Application by National Highways for A47 Wansford to Sutton Dualling

The Examining Authority's written questions and requests for information (ExQ1)

Issued on 18 January 2021

Annex B – Site Compound and Storage Areas

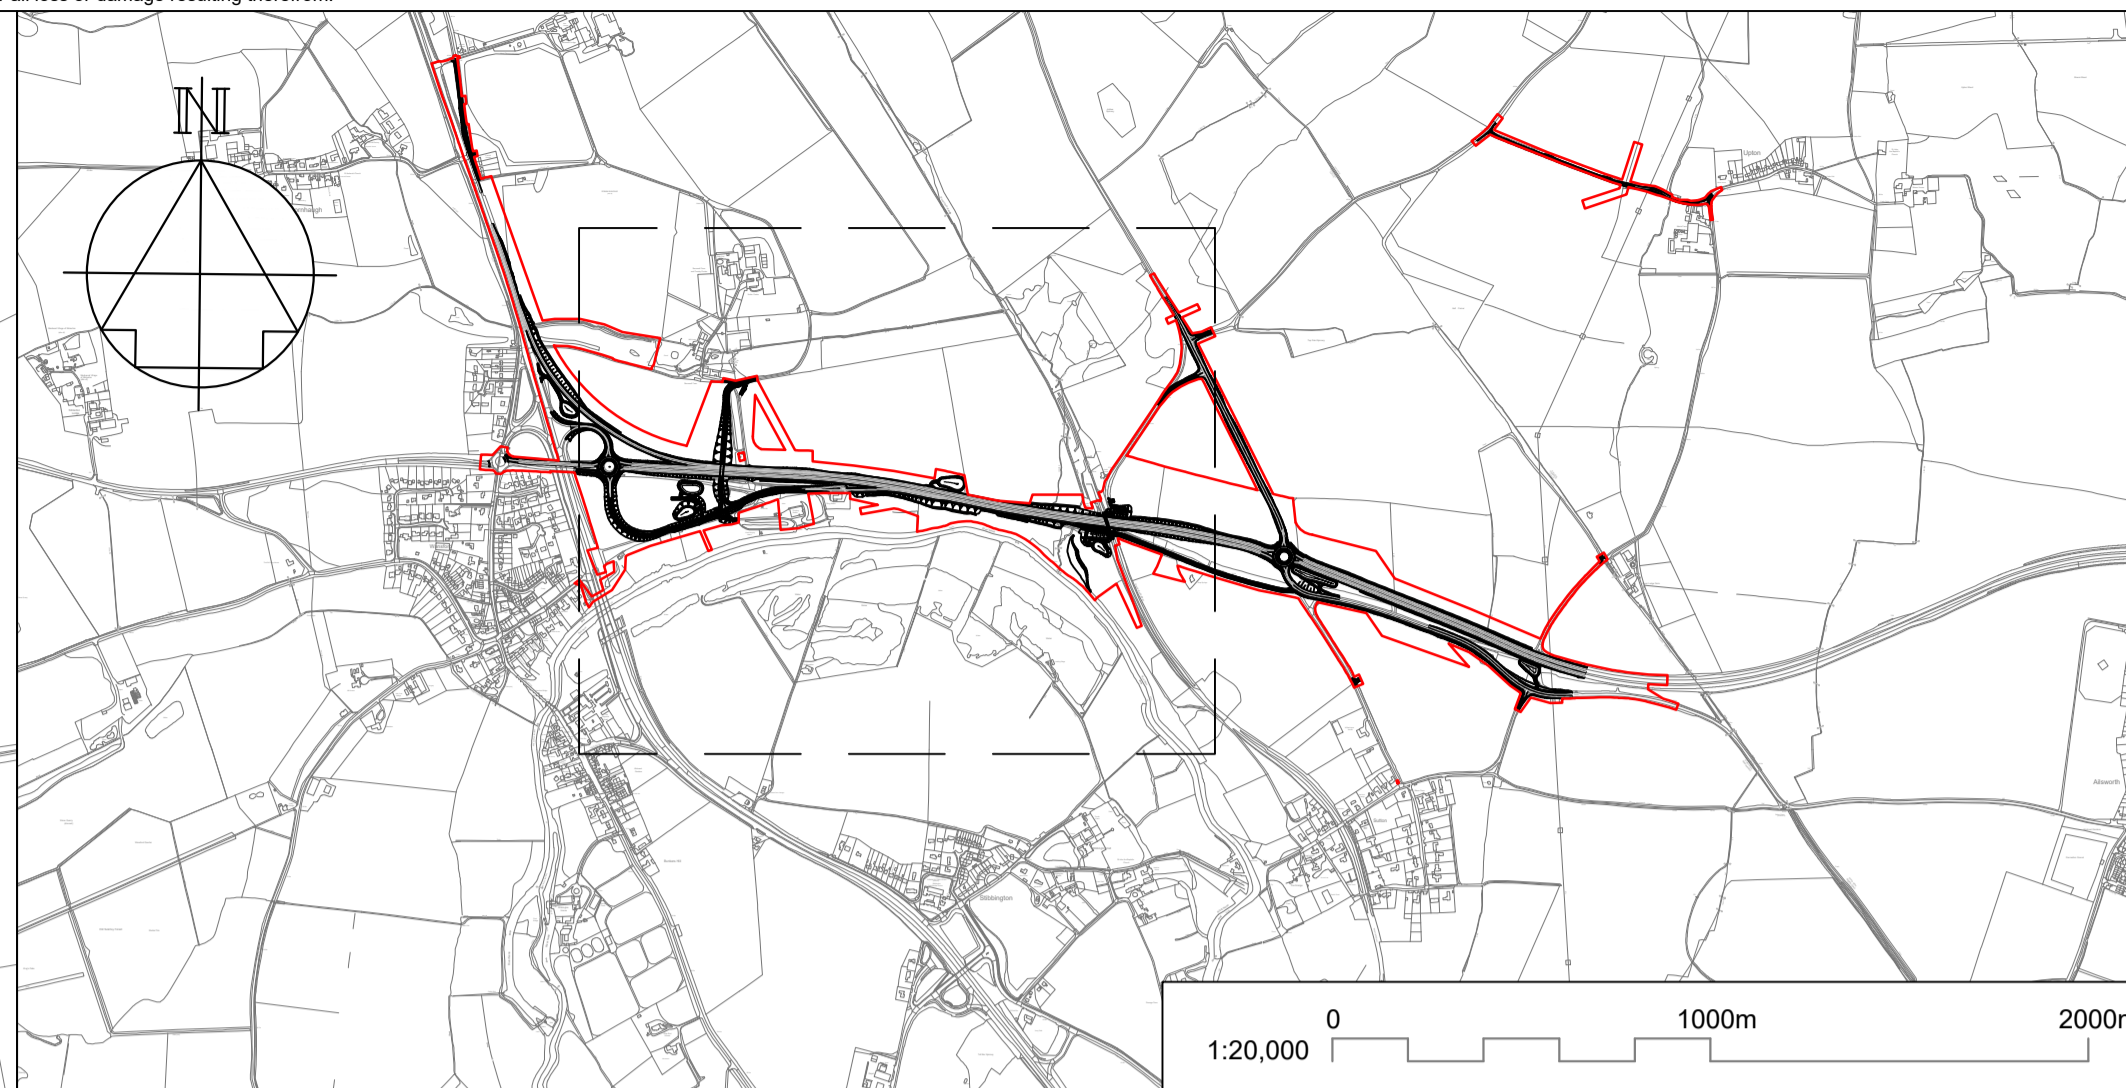
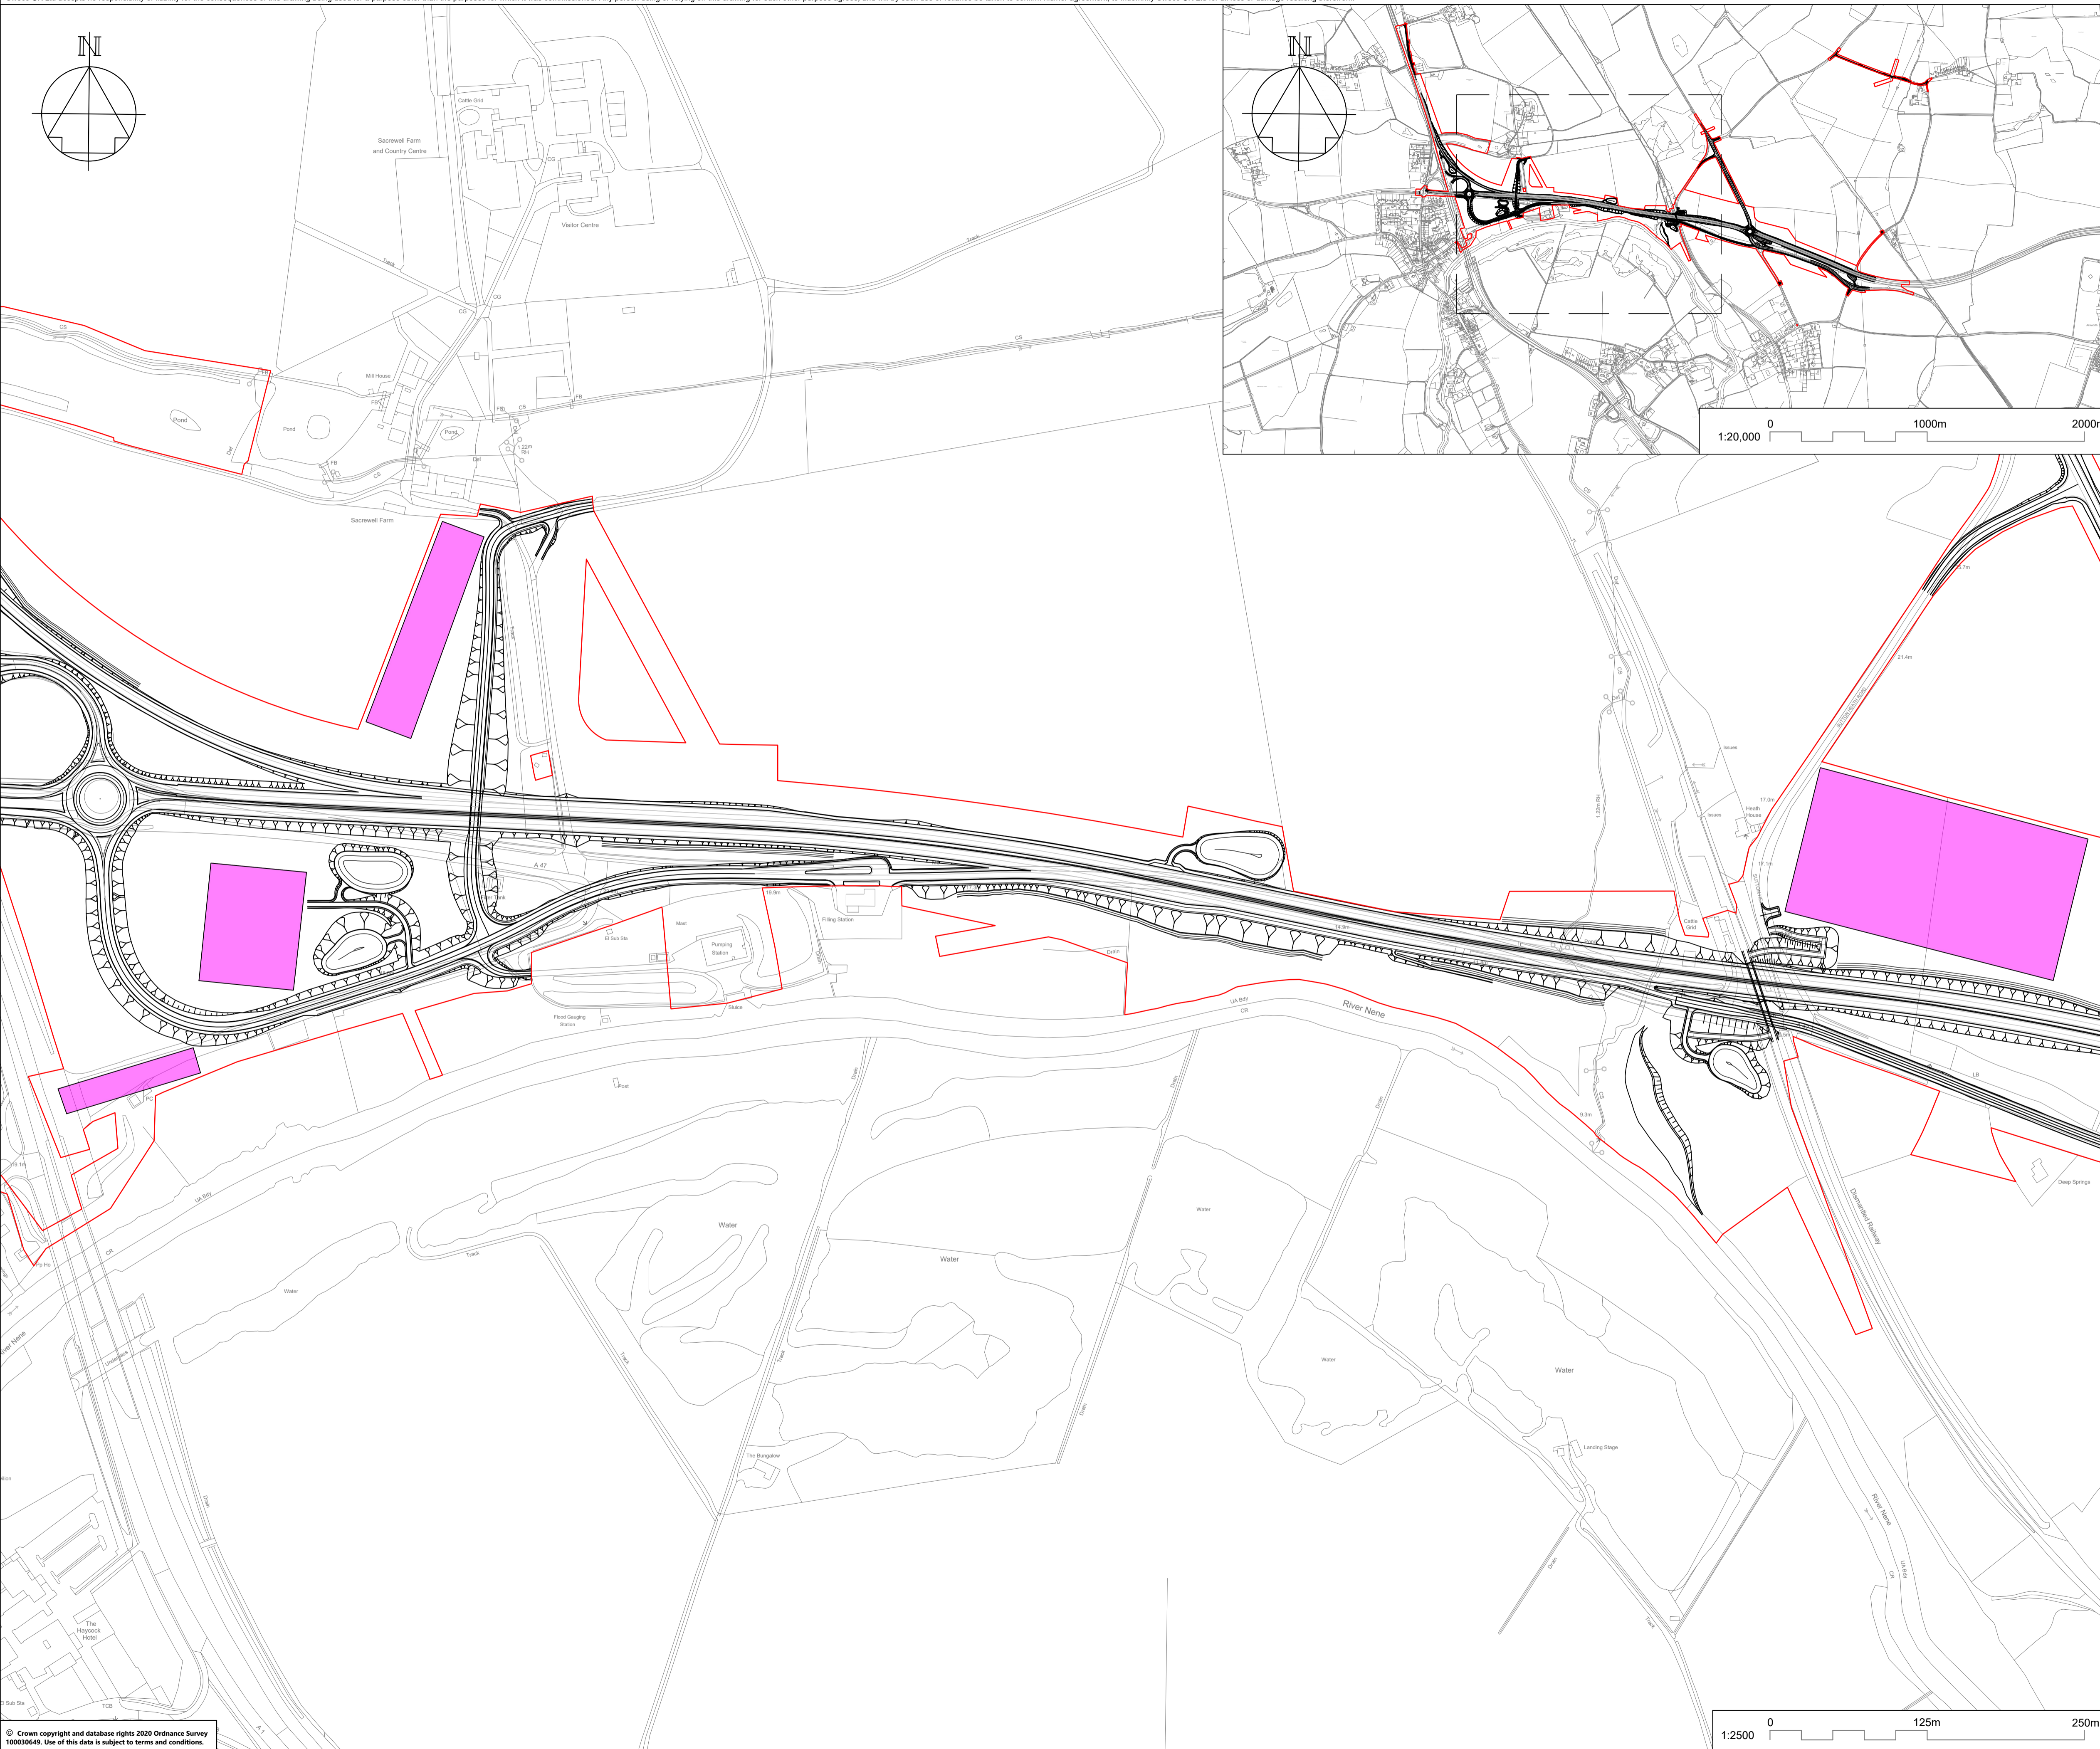
ExQ1	Question to:	Question:
		(It is appreciated that this may also involve changes to the dDCO, particularly to deal with limits of deviation.)
1.0.5.	The Applicant	Works Plans The key to the original version of the Works Plans [APP-006] included "Construction Compound"; this was not included within the plans themselves and this has been omitted from the key from the revised version [AS-006]. Could the Applicant please clarify the position geographically of any proposed construction compounds.
